Consultation Response from: KC Environmental Health (Pollution & Noise Control)		
2026/91494 Land off, Penistone Road, Birdsedge, Huddersfield, HD8 8XP		
Outline application for erection of residential development, including associated infrastructure works. All matters reserved except means of access into (but not within) the site from Penistone Road.		
Date Responded: 16/07/2026	Responding Officer: KB	Responding Ref: WK/202619825
<u>Contaminated Land</u> Our records indicate the site is adjacent to potentially contaminated land (Our site ref: 78/23) which is a former mill and gasworks site. A Phase 1 Geotechnical & Geo-environmental Site Investigation by Eastwood Engineers Ltd dated 29th March 2026 (Ref: 50175-ECE-XX-XX-RP-C-0002) has been submitted in support of the application. The report includes geotechnical information, which falls outside the remit of Environmental Health. This consultation response focuses solely on the land contamination aspects of the report. The site comprises an area of 3.17ha of undeveloped agricultural land with no recorded history of significant industrial activity, and therefore there are no identified major on-site sources of contamination. Publish

**Graph 1 NO<sub>x</sub> Verification Factor**

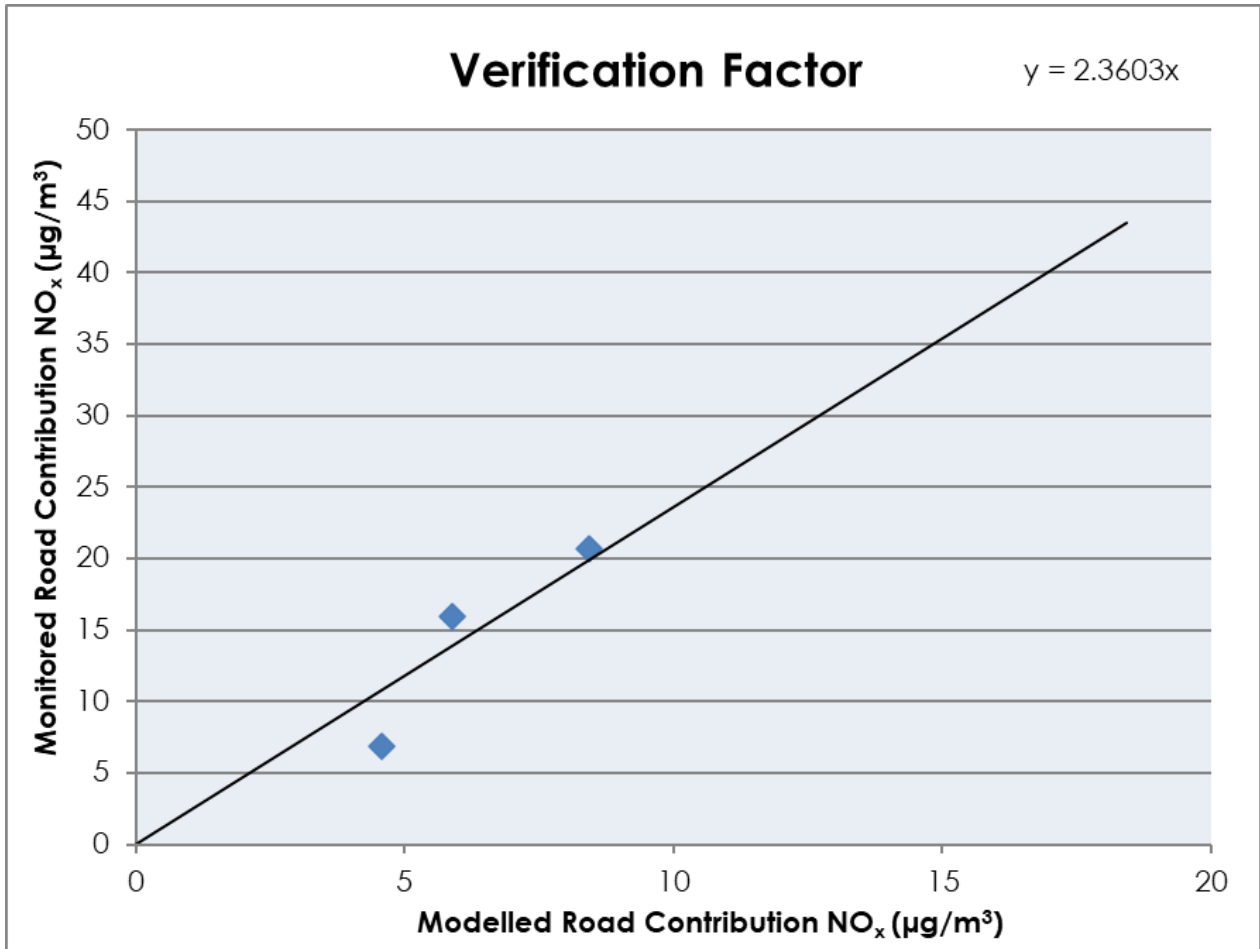
The assessment derives a verification factor of 2.3603 from the comparison of monitored and modelled NO_x concentrations. However, limited information has been provided regarding overall model performance and uncertainty. The verification section does not include supporting statistical indicators such as RMSE, correlation coefficient (R^2) or fractional bias, and provides limited commentary regarding model uncertainty in accordance with DEFRA TG22 guidance. Consequently, insufficient information has been provided to fully assess the robustness of the verification process and the level of confidence that can be placed in the verified model outputs.

- further justification of the construction phase assessment, including consideration of construction traffic impacts or justification for their omission.
- clarification of any assumptions relating to demolition activities.
- details of the methodology used to identify the affected road network and screening criteria applied.
- confirmation of development trip generation, traffic data inputs and cumulative development assumptions.
- further justification of the traffic data used within the model verification process.
- justification of the monitoring locations used for model verification and their relevance to the application site.
- additional information regarding model performance, uncertainty and verification in accordance with relevant DEFRA guidance; and
- any amendments to the assessment conclusions or mitigation measures arising from the above.
